**KIRKLEES METROPOLITAN COUNCIL
INVESTMENT & REGENERATION SERVICE**

DELEGATED DECISION TO DETERMINE PLANNING APPLICATIONS

Reference No:	2022/62/92971/W
Site Address:	59, Fixby Road, Fixby, Huddersfield, HD2 2JB
Description:	Erection of two storey side and two and single storey rear extensions with external alterations
Recommending Officer:	Laura Yeadon

HOUSEHOLDER DELEGATED REPORT

DRAWING REF : **1978-22-003** REVISION: **E** SCALE: **As Shown**

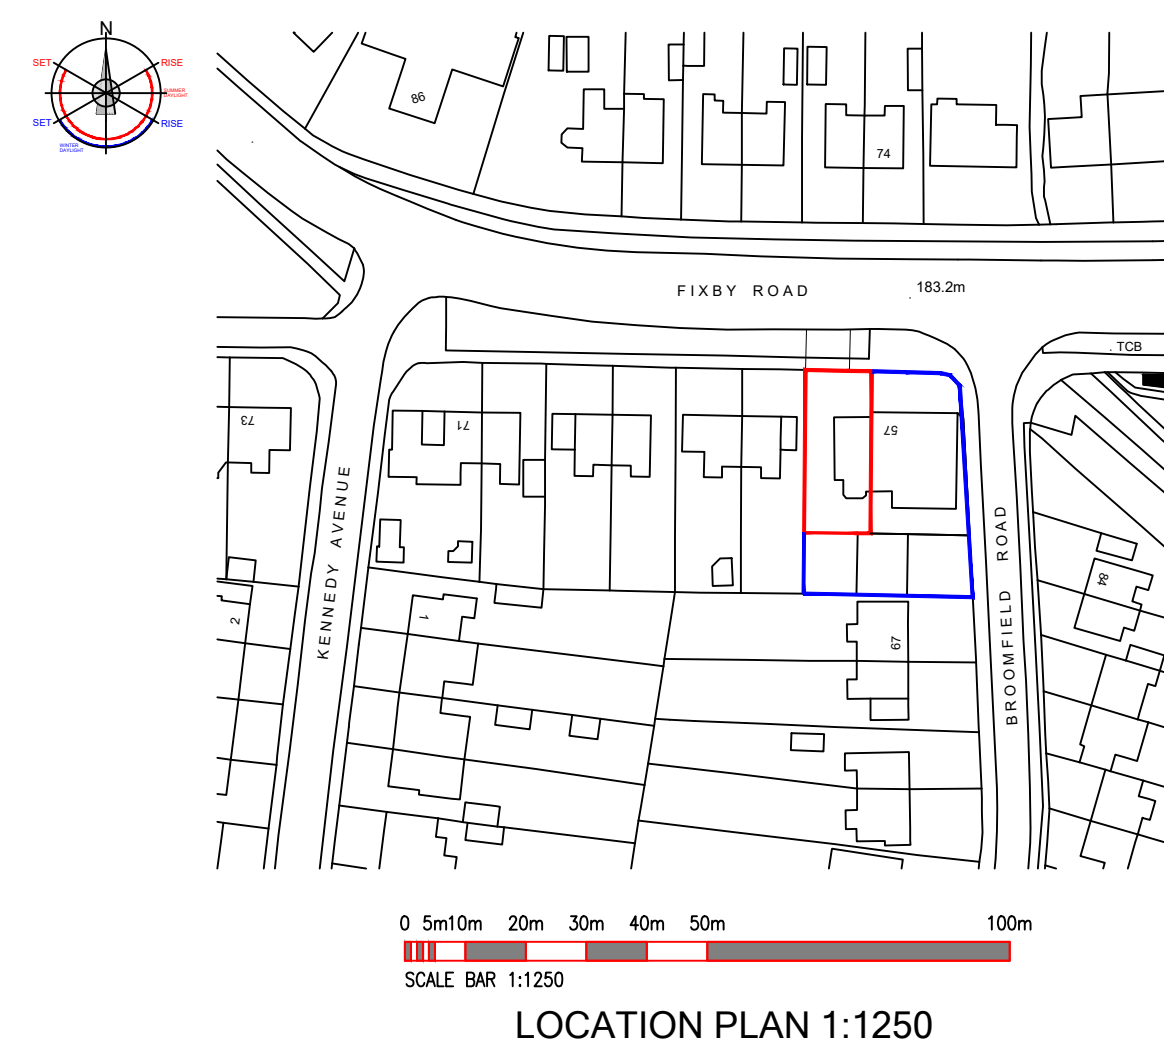
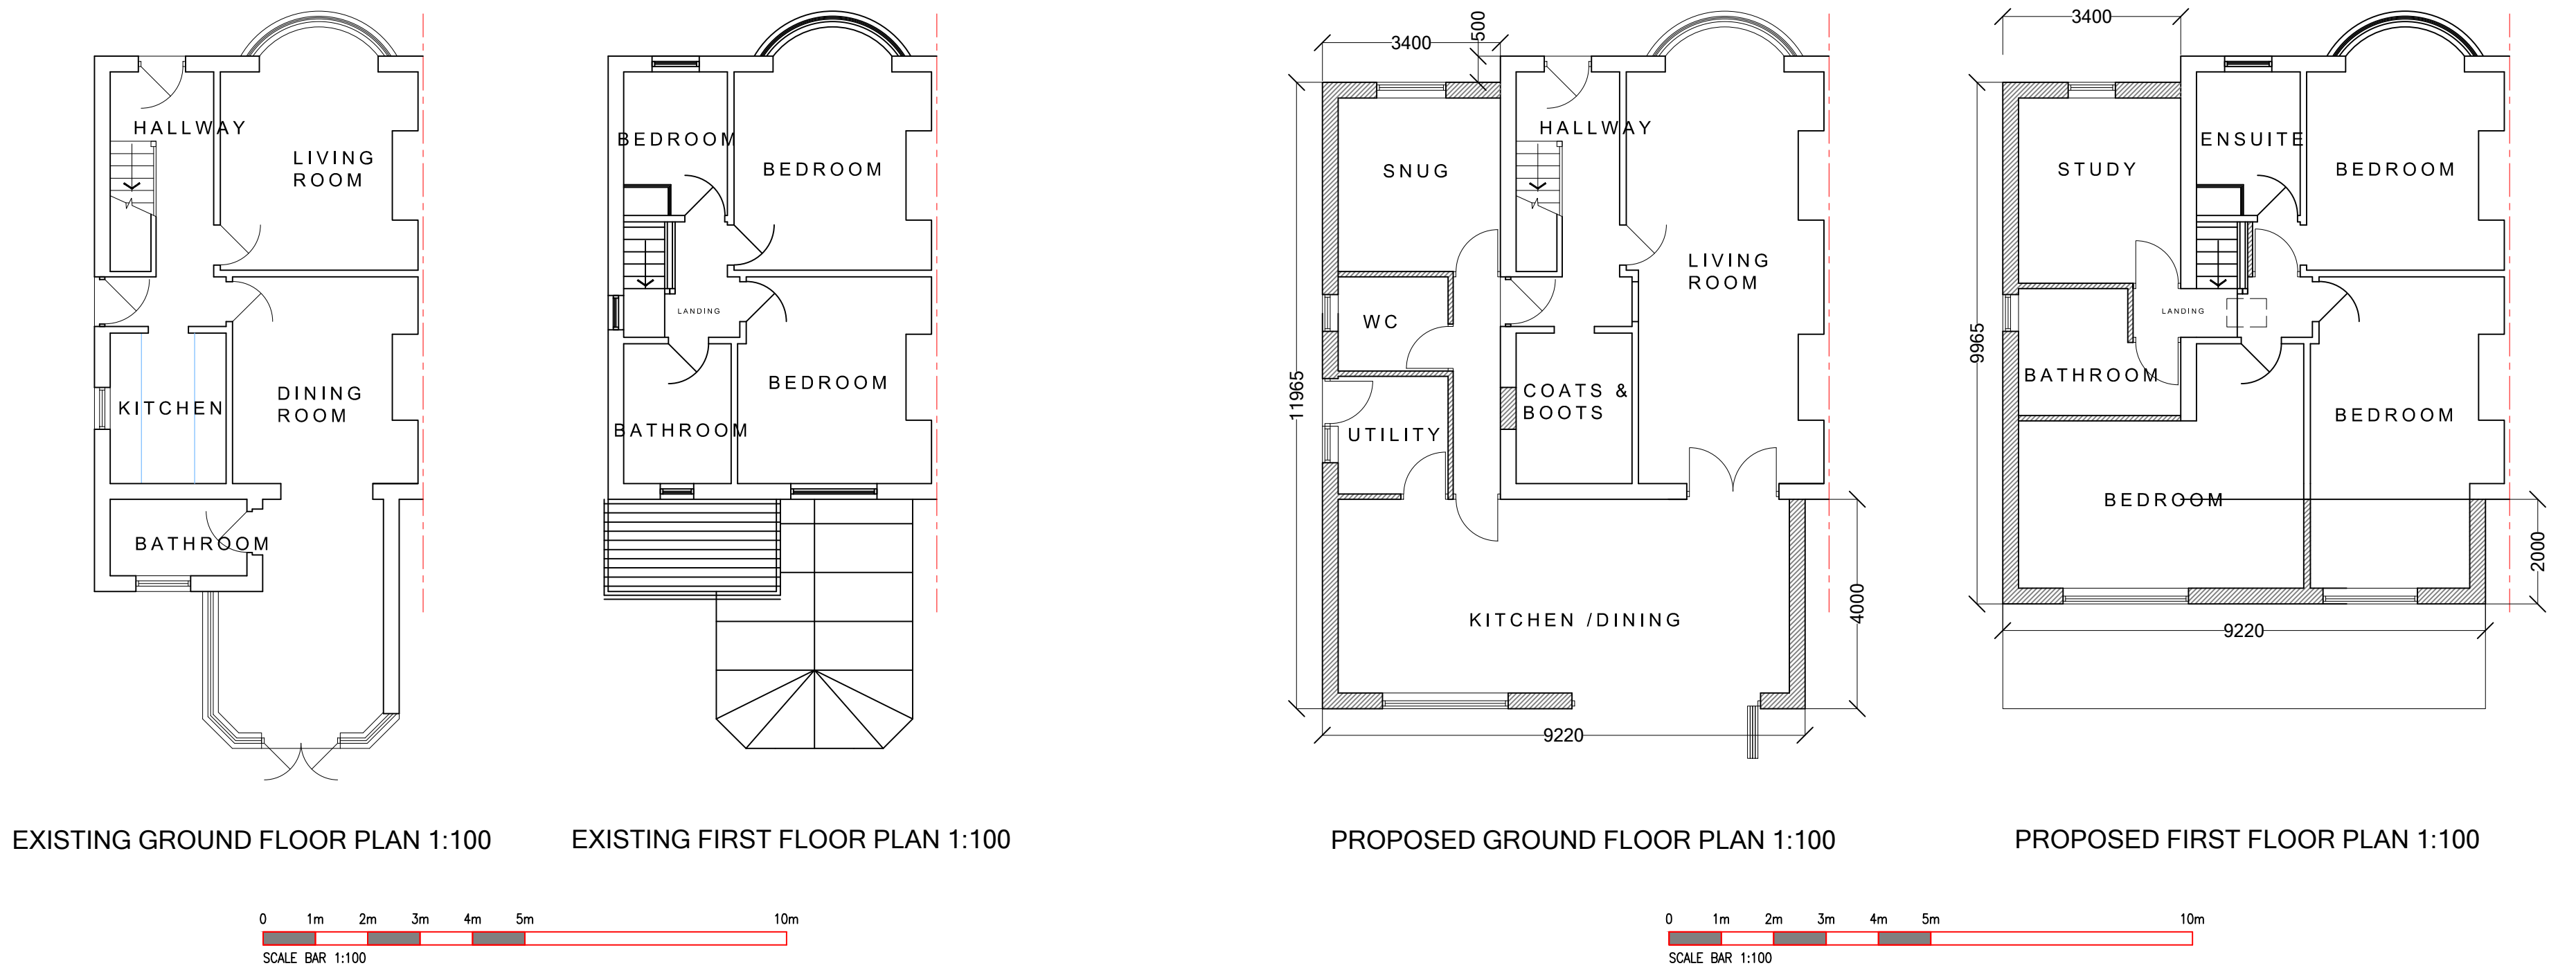
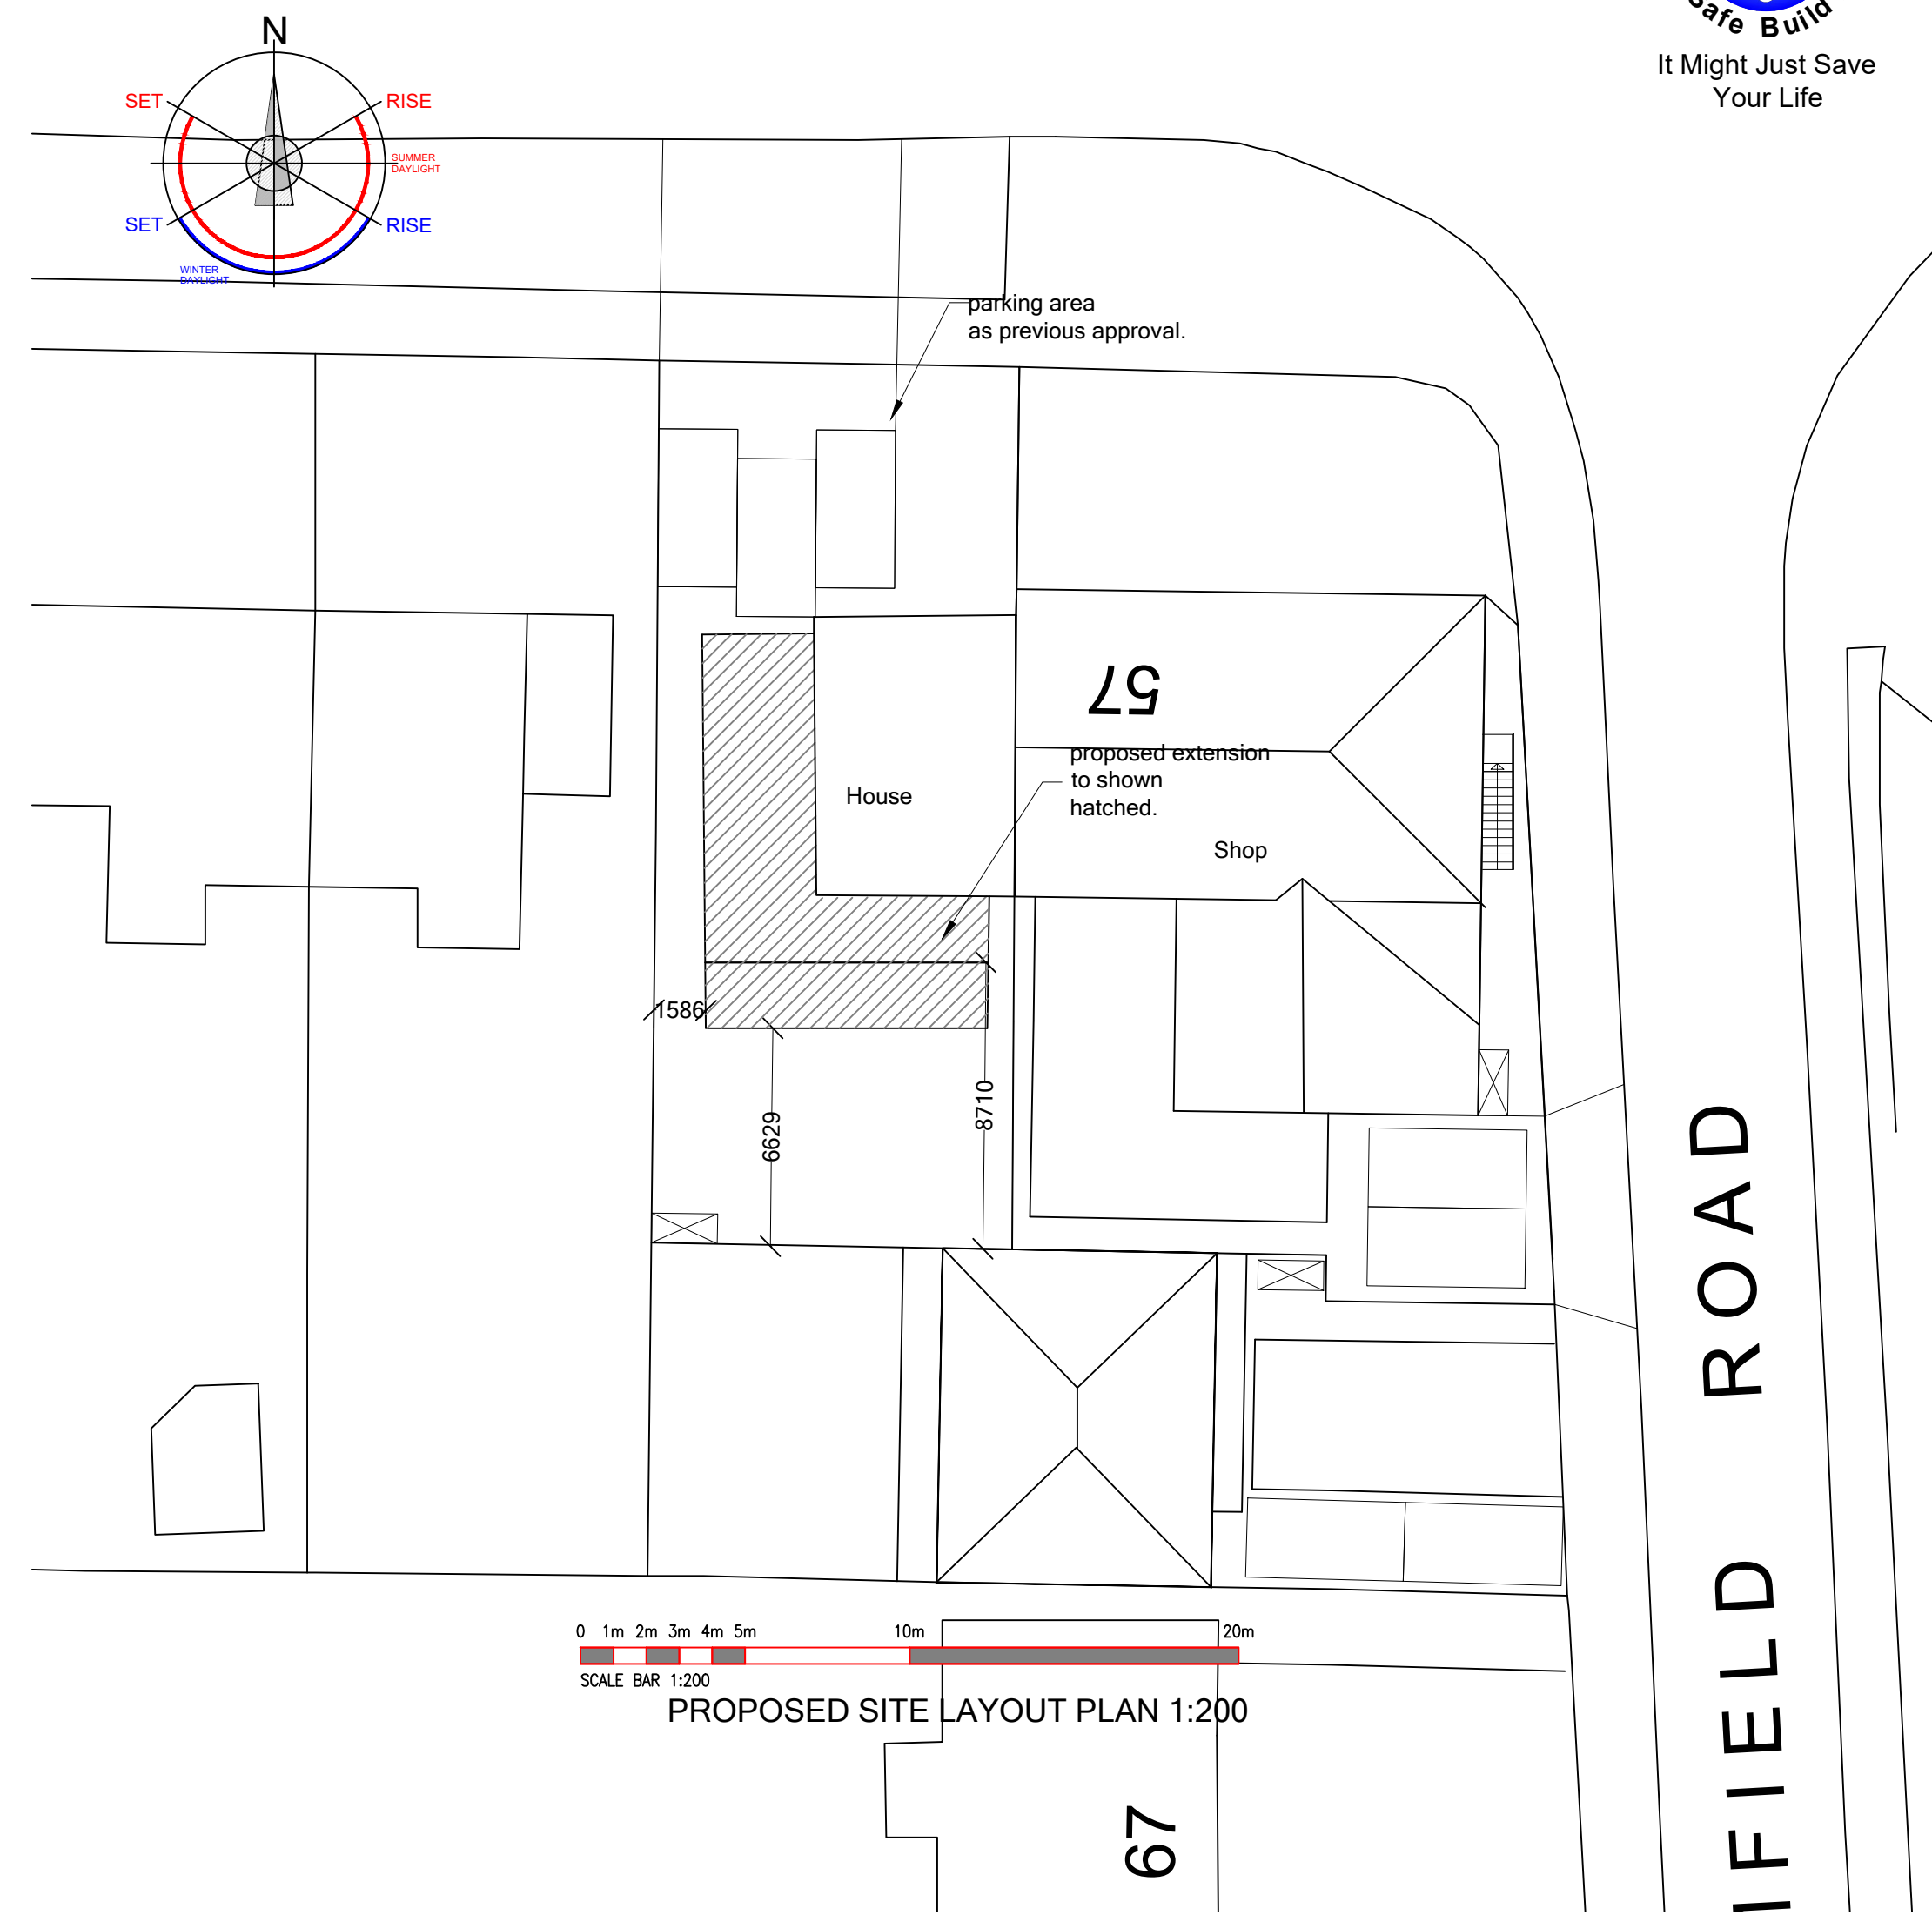
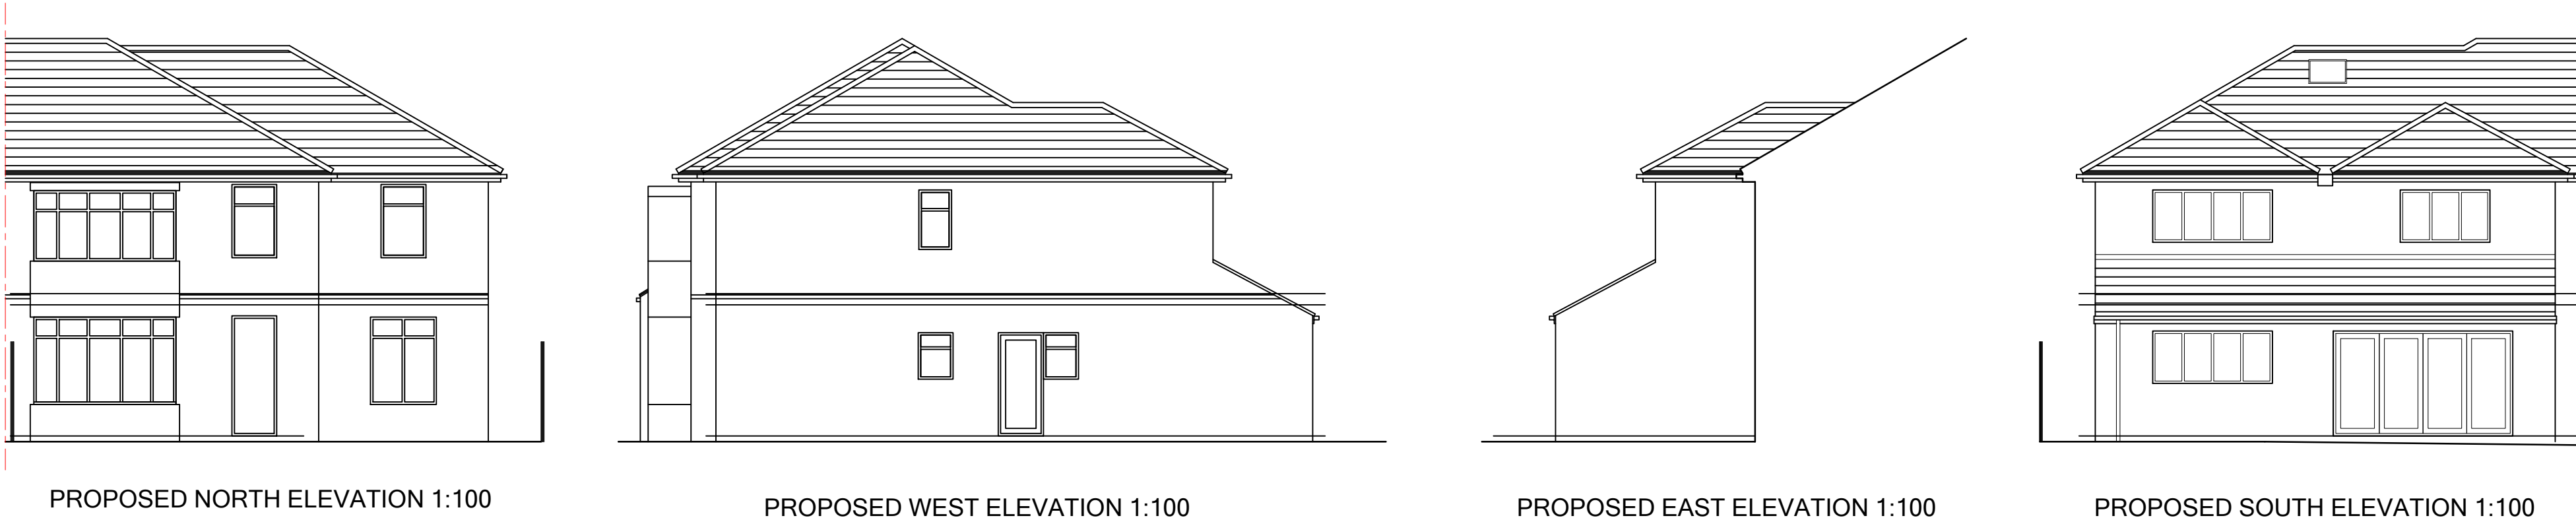
The proposed works would result in a wrap around style extension to the property. The two storey extension would be set back from the front elevation of the property by 0.5 metres and would project to the side by 3.4 metres spanning the full depth of the property, projecting off the rear elevation by 4 metres at the ground floor level.

The extension would span the width of the dwelling being set in from the shared boundary with the attached property by 0.5 metres. To the rear, the extension would be single storey at the 4 metre projection and at first floor the extension would project 2 metres. The roof line of the two storey extension would be set down from the existing with the double hipped roof to the rear set much lower than the existing roof.

Rear extensions should:	<u>Yes - COMPLY</u>	<u>No - JUSTIFY</u>
Preserve a back garden of a reasonable size, with a general principle that at least half the garden area is retained	Yes – the amenity area to the rear would be preserved to a reasonable size	
Be set behind the original building, and not projecting beyond the sides	Yes – it is proposed that the rear extensions would be incorporated into the development by tying into the proposed two storey side extension and rear roof slope, and being set

lower than the ridge of these roof slopes.	
Maintain external access to the rear garden	Yes – external access to the rear garden will be maintained to the side of the proposed extension	
Two storey rear extensions should:		
be proportionate to the size of the original house and garden	Yes – the size is considered proportionate to the original house and garden having regard to the building to which it is attached and the level of development previously undertaken to that property. In this case the proposal would read as proportionate in this context.	
not normally exceed 50% of the total area of land around the original house (including previous extensions and outbuildings)	Yes – it would comply with this	
not project out more than 3 metres from the rear wall of the original house or by 4 metres for detached properties		No - the rear extension would project by 4 metres at ground floor and 2 metres at first floor – adjacent property No. 57 is retail at ground floor with residential above – within same ownership. The building to which the dwelling is attached has been significantly extended and is of a size and scale which is such that in this case a ground floor 4m projection from the dwelling would not

have a significant impact.
not exceed a height at the eaves of 3 metres where the extension is within 1.5 metres of the property boundary		No – the rear extension would have an eaves height of over 3 metres and would be within 1.5 metres of both side boundaries – this due to the fact the extension is two storeys in height. Given the development to the attached building this is considered to be acceptable in this case.
be separated from the property boundary, such as a wall, fence or hedge, by at least 1.5 metres		No – the rear extension would not be set in by both side boundaries by 1.5 metres however is set in from the boundary with No. 61 by 1.2 meters which retains a sense of space around the building with the existing dwelling already developed up to the boundary with no.57.
not adversely affect habitable room windows where they adjoin a neighbour's boundary	Openings within side elevation of No. 61 are to a garage with openings within that dwelling that appear to be non-habitable

Side extensions should:		
Ensure reasonable levels of natural light to the habitable rooms in neighbouring properties	Yes – the proposed side elevation would be set in from shared boundary and separated from neighbouring dwelling by single storey attached garage. Whilst

there would be some impact to windows serving the garage these are non habitable and it is considered it would be unreasonable of the LPA to refuse permission on such as basis.	
Positioning windows to minimise or avoid any potential overlook into neighbouring gardens	Yes – the openings within the side elevation facing the No. 61 would be non-habitable openings. Other windows would not protrude beyond the plane of the front elevation of the host property, and are considered sufficient distance from properties to the rear to ensure no significant impact.	
Two storey side extensions should:		
not take up all or most of the space to the side of a house	Yes – the extension would be set in from the shared boundary with No. 61 by 1.2 metres	
maintain a 1 metre gap to the side boundary to ensure the building is not too close to a neighbouring property	Yes – it would comply with this	
be set back at least 500mm from the front wall of the house	Yes – the extension is set back from the front of elevation of the house by 0.5 metres

retaining host property as dominant element	
Height, scale and massing	• KDP 1 and 2 of the SPD • Policy LP24 Design (a), (c) and (d) of the KLP • Chapter 12 of the NPPF	Increase in massing by virtue of cumulative impact of extensions. Hipped roof design retained within the side extension and also, low hipped roofs within rear elevation	✓
Facing materials and detailing	• KDP 9 of the SPD • Policy LP24 Design (d) (iii) of the KLP • Chapter 12 of the NPPF	Facing materials to match the existing with fenestration details also in keeping. Two storey bay window detail retained within existing property	✓
Roof style	• KDP 1 and 2 of the SPD • Policy LP24 Design (a), (c) and (d) of the KLP • Chapter 12 of the NPPF	Hipped roof to side extension and low hipped roofs to rear elevation. In keeping with original roof	✓
Window proportions	• KDP 1 and 2 of the SPD • Policy LP24 Design (a), (c) and (d) of the KLP • Chapter 12 of the NPPF	Openings to match existing openings in terms of size and proportions. Proposed bank of patio doors within ground floor rear extension acceptable for a residential extension	✓

Relevant key design principle (KDP) of the SPD, Policy in the Kirklees Local Plan and the NPPF	Further comments	✓ / X / N/A
Impact on privacy of neighbours (to sides, rear and front)	• KDP 3 & 4 of the SPD • Policy LP24 Design (d) (iv) • Chapter 12 of the NPPF	Openings facing No. 61 are non-habitable and therefore minimal concerns – no openings facing attached neighbouring property. There are no boundary treatments separating the host dwelling from the amenity space for the attached property or the proposed amenity space for the converted and extended garage/outbuilding given under one ownership. There is no boundary screening between the habitable room openings within the extensions and outbuilding/garage and the proposed garden area for the dwelling however as the proposed	✓

YES / NO	SUMMARY
Negotiations/Amendments during course of application	Yes	Amended plans were requested which demonstrated the extent of development proposed due to other applications submitted within the site – received 9th October 2023 Further amendments were requested to align the application with the current requirements of the SPD whereby the roof line of the two storey side extension was lowered – received 8th February 2023 under reference number 1978-22-003 – Rev: D. It was noted that the red line boundary of the site included land forming part of the adopted highway

which is outside the ownership of the applicant. As a consequence, the red line boundary was reduced to only include land owned by the applicant.
Parish/Town Council comments sought	N/A	
Planning History		<u>Application site</u> 2019/92709 – Erection of extension and alterations to outbuilding and garage to form one dwelling and widening of vehicular access to Fixby Road – Approved <u>Attached property No. 57</u> 1989/07343 – Erection of 2 storey extension to form enlarged sales area, 2 bedrooms and bathroom – Approved 2005/94734 – Alterations to existing garage – Refused 2006/94561 – Erection of storage unit – Approved 2011/92679 – Installation of ATM and associated works – Approved 2019/92708 – Certificate of lawfulness for proposed change of use of grand floor from residential to retail – Refused 2022/93096 – Erection of extension and external staircase – <i>under consideration – not yet determined – committee decision request submitted</i> 2022/93373 – Erection of extensions and alterations to outbuilding and garage to form one dwelling – <i>under consideration – not yet determined</i>

Pursuant to article 35 (2) of the Town and Country Planning (Development Management Procedure) Order 2015 and guidance in the National Planning Policy Framework, the Local Authority have, where possible, made a pre-application advice service available, complied with the Kirklees Development Management Charter 2015 and otherwise actively engaged with the applicant in dealing with the application. Amended plans were requested to demonstrate all the proposed works within the blue line boundary and also to set the roof down to comply with the SPD.
